**Lancashire
Constabulary**

23rd September 2014

**Planning application Reserved Matters 3/2014/0815 Land North of
Riddings Lane Whalley. Application for 71 Domestic Dwelling Houses
and associated works.**

LAND TO THE NORTH OF RIDDINGS LANE, WHALLEY

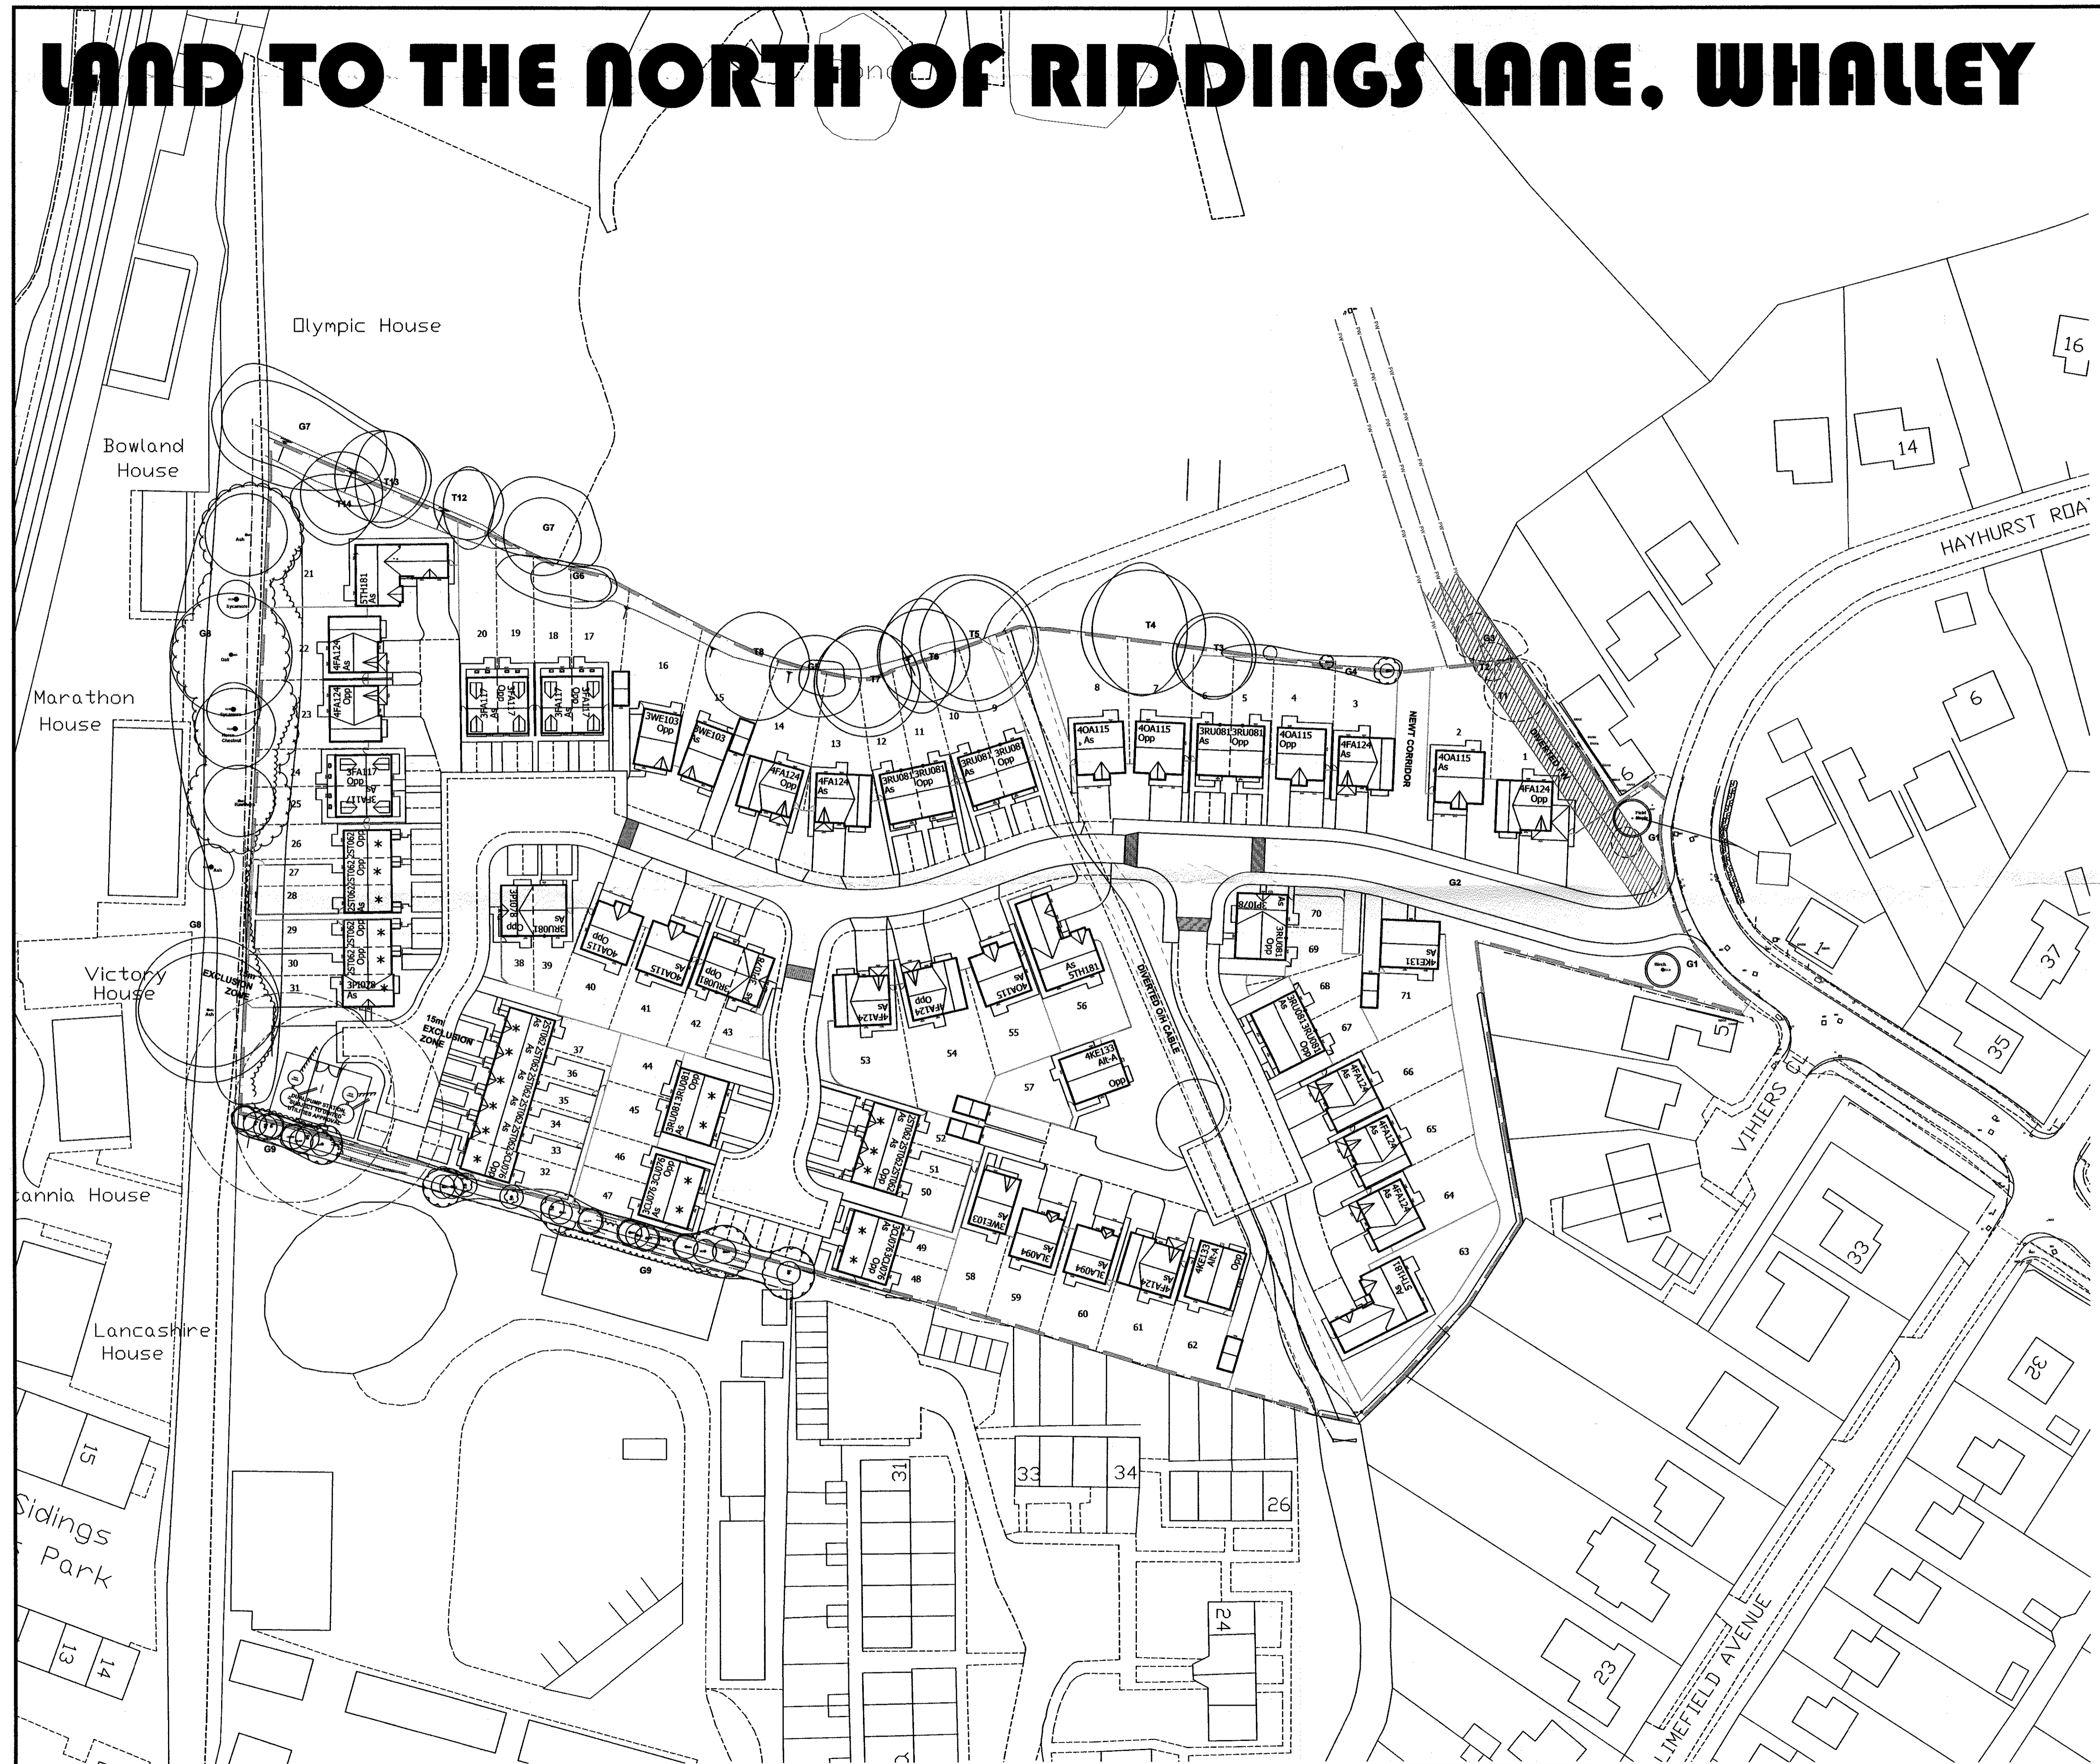
- Each property should be fitted with PAS 24:2012 front door sets, not only will this sustain attack they are fitted with door chains and viewers so the occupant can see who is at the door without opening it. The glazing must incorporate one pain of laminated glass meeting the requirements of BS EN 356:2000 class P1A.
- If the individual properties are not to be fitted with an alarm then at least a 13 amp non switched spur should be fitted for the future instalment of an intruder alarm.
- Each house to have front and rear or the property security lights.
- Locked gated access to the rear of the property.
- 1800mm close boarded wooden fencing around the boundary.
